From: Lauren Wiltshire [REDACTED]
Sent: 24 May 2019 10:35
To: Simon Davis <Simon.Davis@arun.gov.uk>; Laura Gibbons <Laura.Gibbons@arun.gov.uk>
Subject: RE: Planning Consultation on FP/42/19/DOC

Engineers Comments Regarding Condition 7

NB: Sub-base construction depths are shown as minimum construction requirements. Specific construction depths vary, e.g. where sub-base falls (to collection point) in opposite direction to surface falls. See respective Drainage Layout for specific sub-base levels.

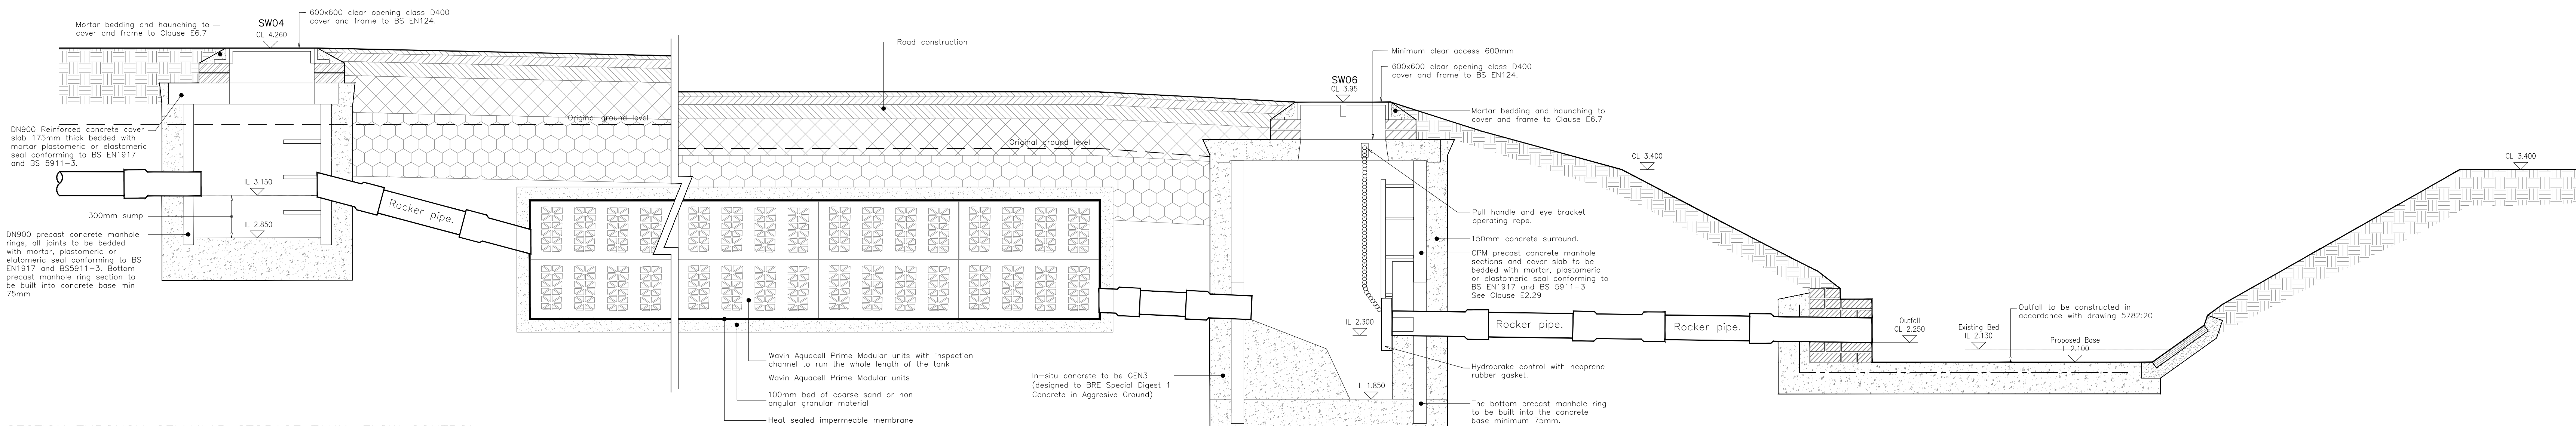
1. Catchpits must be provided upstream of all connections into the attenuation tank.
Please refer to drawing 5782:23 Construction Details demonstrating manhole SW04 and SW05 should be installed with 300mm deep catchpits.
